28 April, 2020

Harbourside Shopping Centre Redevelopment SSD-7874

1 Shadow Projection JUN 900
9am

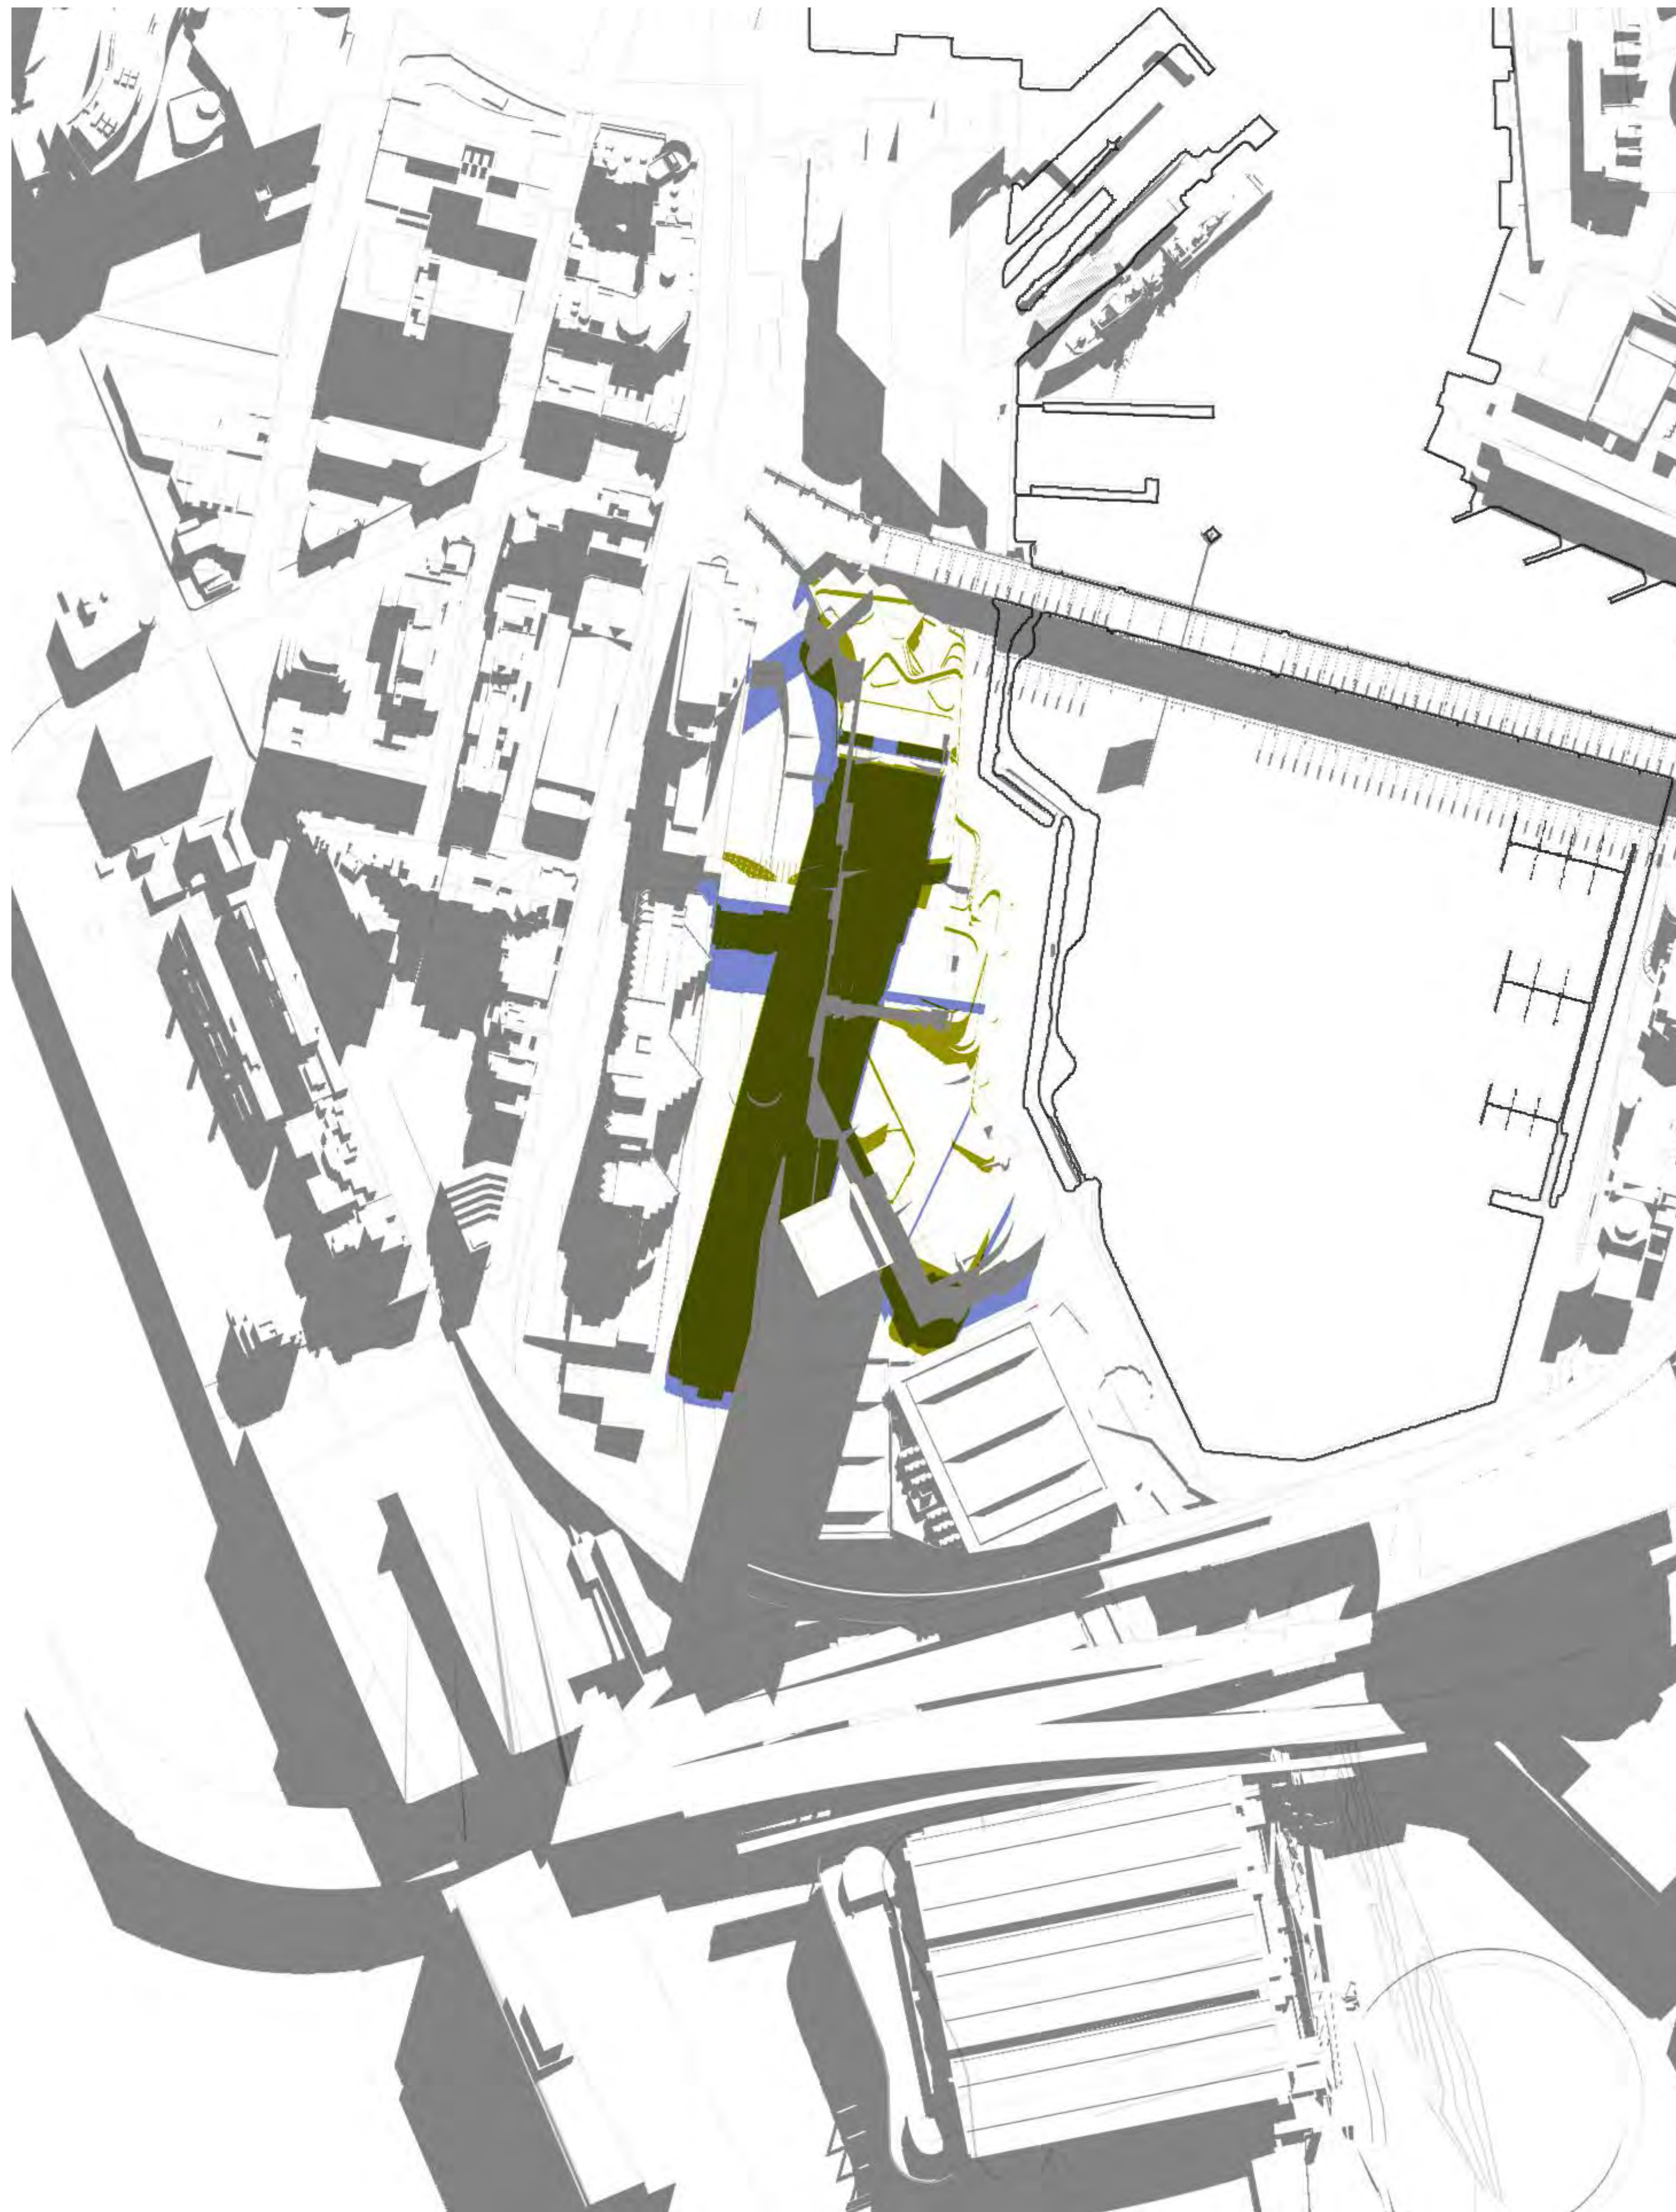
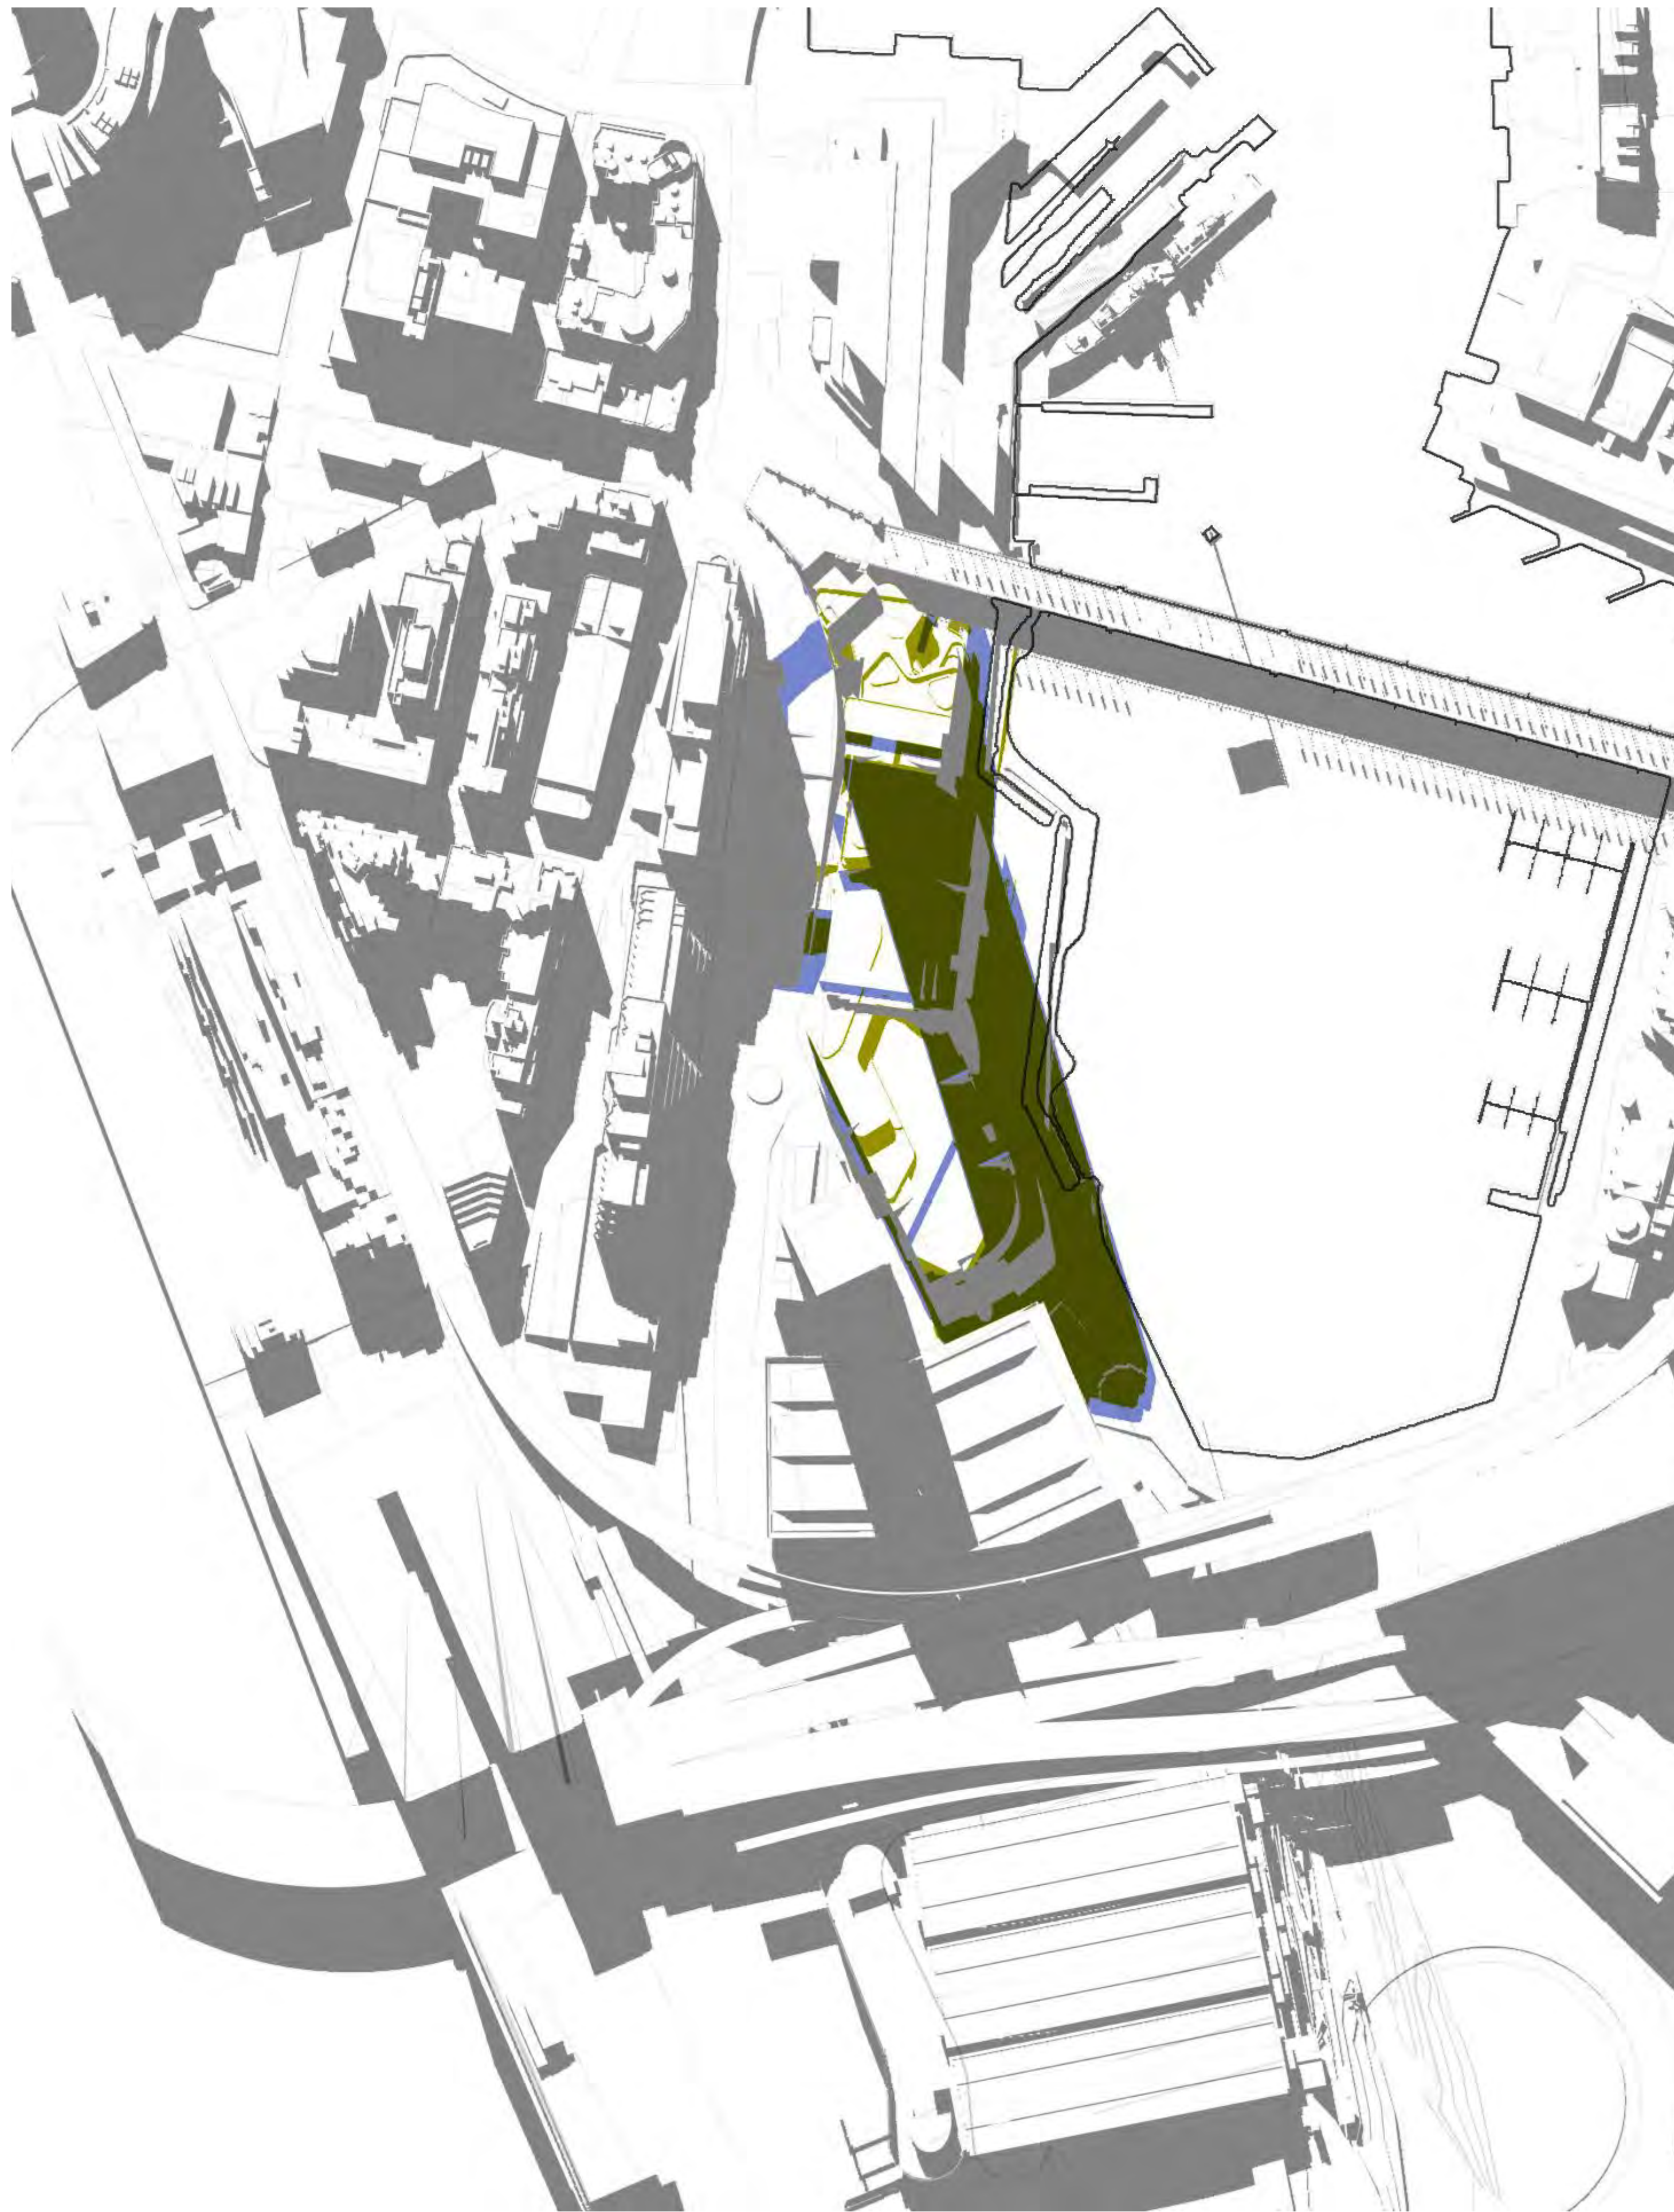
The proposed new podium appears to reduce the width of the existing promenade and increase overshadowing, compounding the impacts of the overshadowing from the new tower proposal particularly in the colder months of the year.
